**City of Portland, Maine - Building or Use Permit**

<b>Permit No:</b> 05-0768	<b>Date Applied For:</b> 06/13/2005	<b>CBL:</b> 385A C006001
------------------------------	--	-----------------------------

<b>Proposed Use:</b> Single family residence with 12'x10' screen porch and 12'x10' wooden deck	<b>Proposed Project Description:</b> Remove existing deck-replace with 12'x10' screen porch and 12'x10' wooden deck at rear of house
---	---

Add'l notes per  
 Dave D.  
 6/27/05

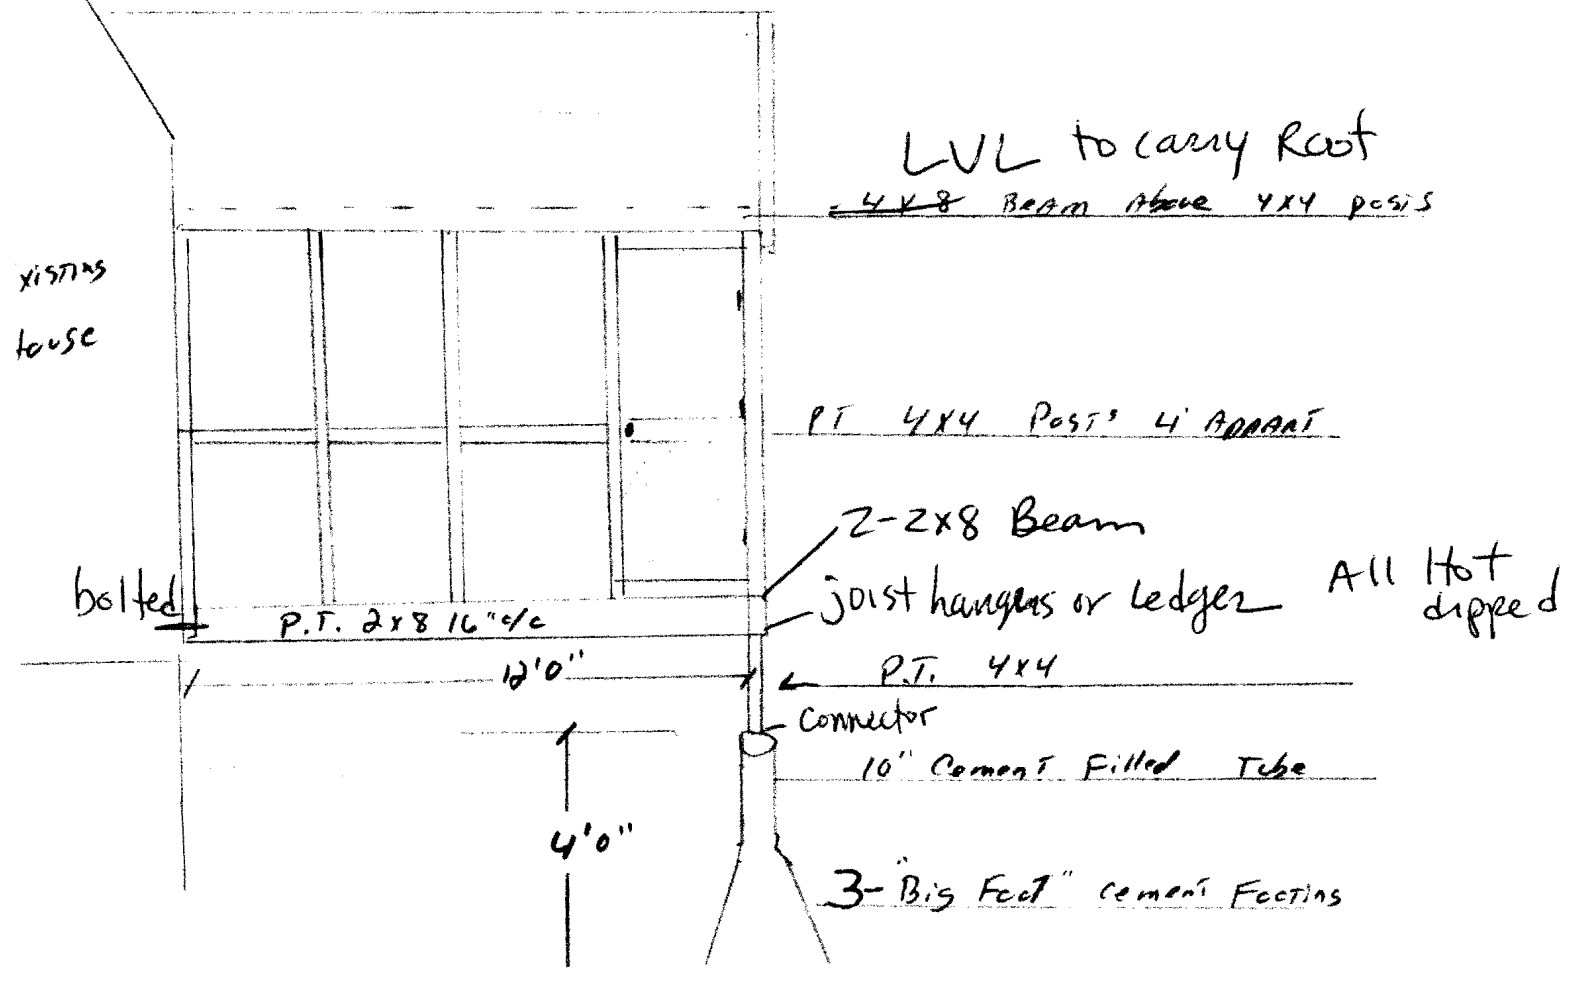
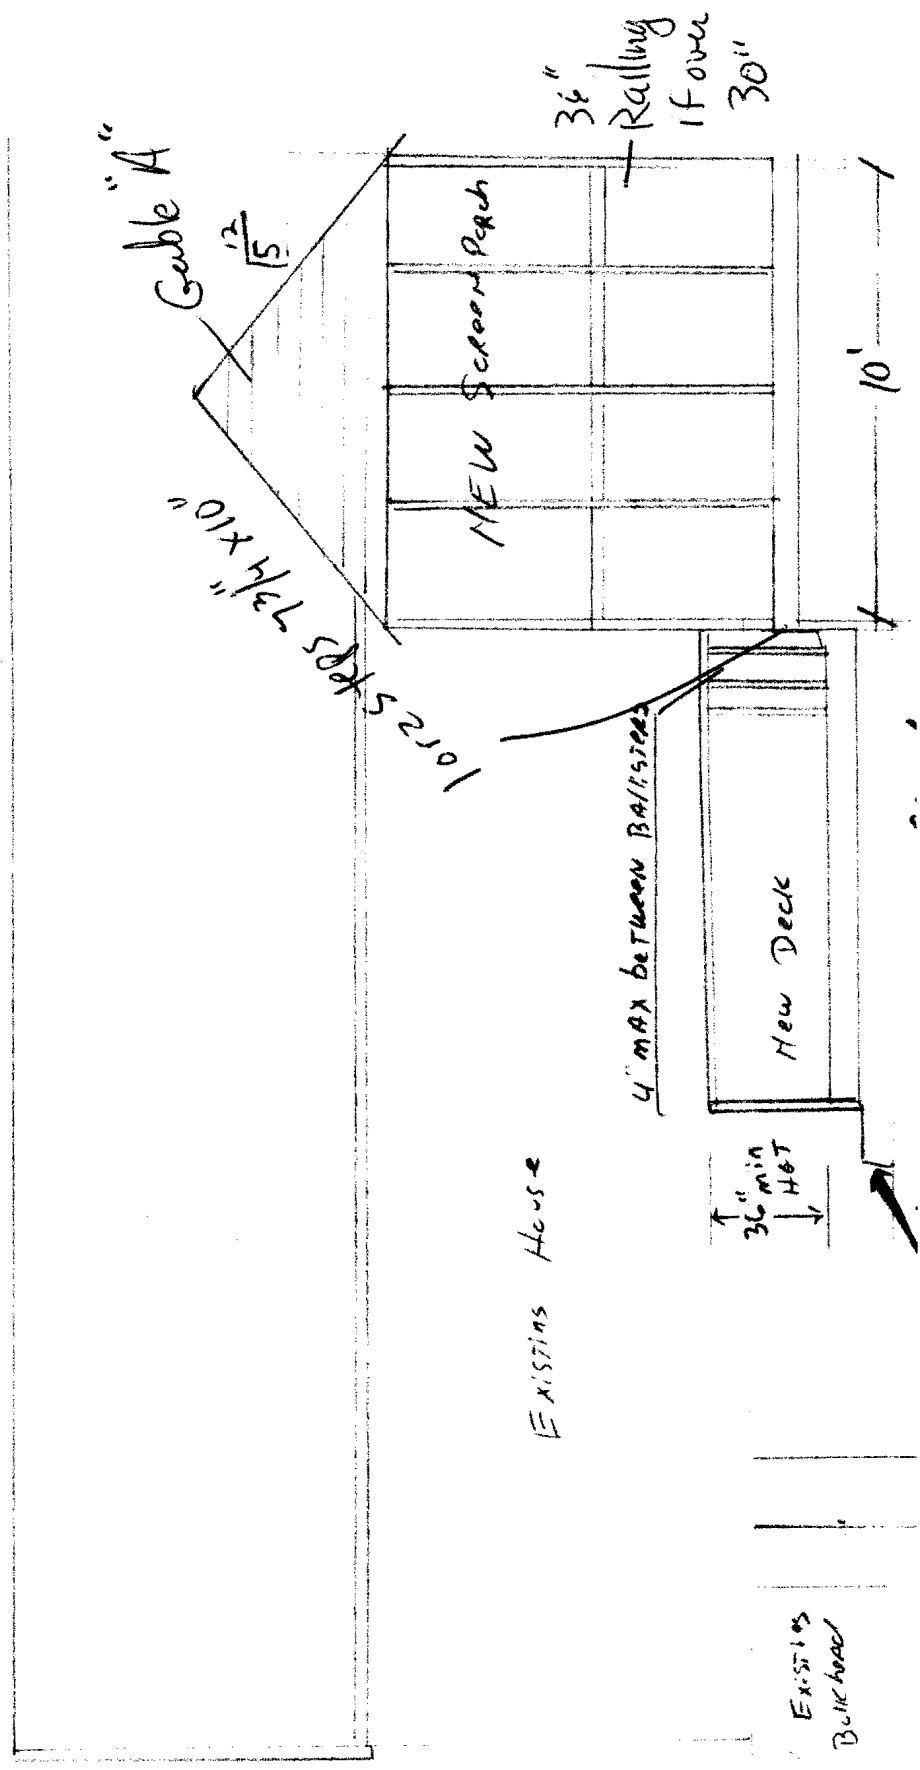
**Dept:** Building      **Status:** Approved with Conditions      **Reviewer:** Jeanine Bourke      **Approval Date:** 06/27/2005  
**Note:** 6/27/05 Spoke w/Dave D. For add'l info as noted on plans, ok to issue      **Ok to Issue:**

- 1) The design load spec sheets for any engineered beam(s) must be submitted to this office.
- 2) Permit approved based on the plans submitted and reviewed w/owner/contractor, with additional information as agreed on and as noted on plans.
